**From:** [Brissette, Renee C.](#)  
**To:** ["Jeremy Shell"](#)  
**Cc:** [Rick Beltramo](#)  
**Subject:** RE: Paseo Marketplace  
**Date:** Thursday, May 18, 2017 4:14:00 PM  
**Attachments:** [SKM\\_C554e17051815590.pdf](#)

Sorry to keep bugging about this. The underground perforated pipe is for **water quality volume**. Therefore, please see my sketch. Can you provide the calculation for the 100 year HGL through the storm system. Also two profiles (one from the exist 84" through the 30" to the double Type D inlet –Subbasin 6 & one from the 18" through the MH to the double Type D inlet –Subbasin 3). Finally, please provide the details for the following:

**C-1**

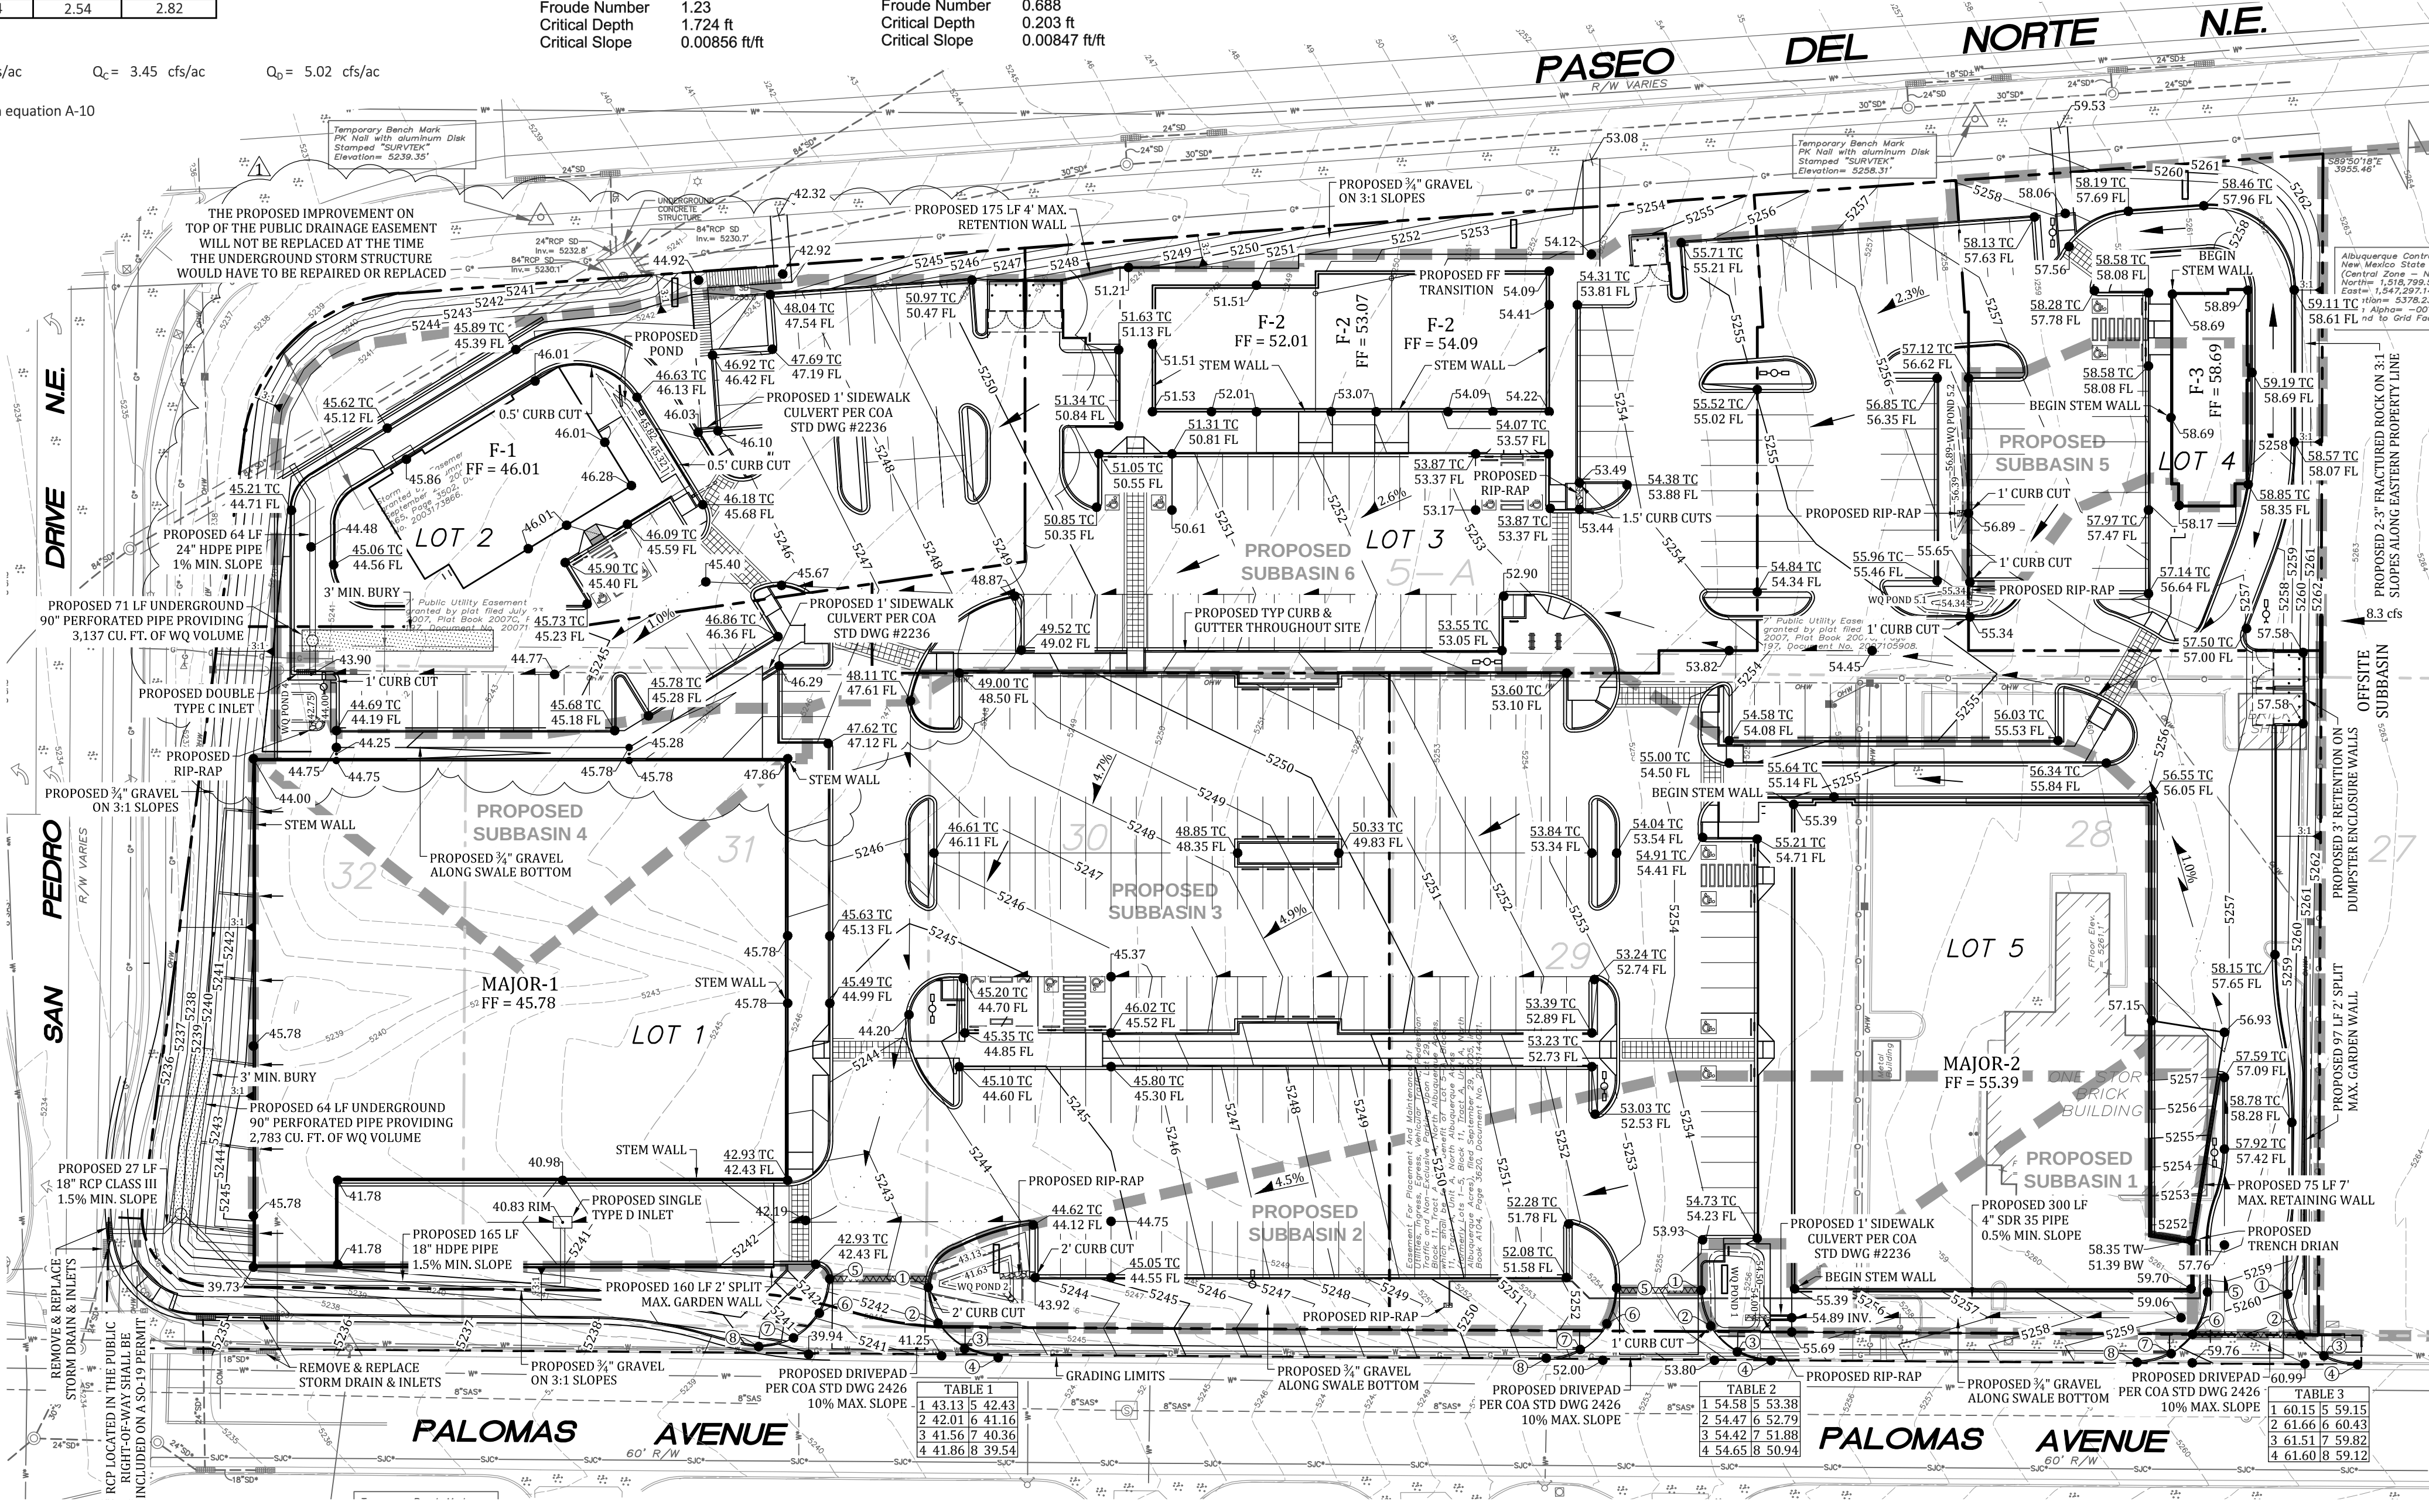
- Connection to the exist 84"
- Connection of the 90" perforated pipe and the double Type D inlet
- Connection of the 90" perforated pipe and the MH
- Bedding detail of the 90" perforated pipe

**All of this should be placed on an additional sheet.** Please provide elevations and type of materials used in the details and profiles. Please note that this additional information will also be asked at DRB. The Connection to the 84" pipe should be included in the DRC workorder set, so please pass on the detail of this to that Engineer so it can be included. Also this connection to the existing 84" needs to be included in the infrastructure list for DRB approval.

I was also thinking about this project. For both of your underground first flush ponds, is there a diversion weir in the double Type D inlets so that the bigger storm events can continue on into the existing 84" storm sewer? If so, can you provide a detail with the weir elevations. If you are

proposing something different than please provide this instead. Thanks.

We are not proposing a diversion weir within the storm drain. The system is designed for the 100-yr storm event. In the case that a bigger storm event occurs or the capacity of the double D inlet is exceeded, water will pond in the parking lot and flow over the western curb and enter San Pedro before inundating any finished floor elevations. Similarly for the single type D inlet, water will pond and discharge to Palomas through the driveway before affecting any structures.

Also, we looked into a Y fitting and decided it would be more simple to do a Tee fitting. The attached plan reflects this change. Please let me know if you would like to see any other revisions.
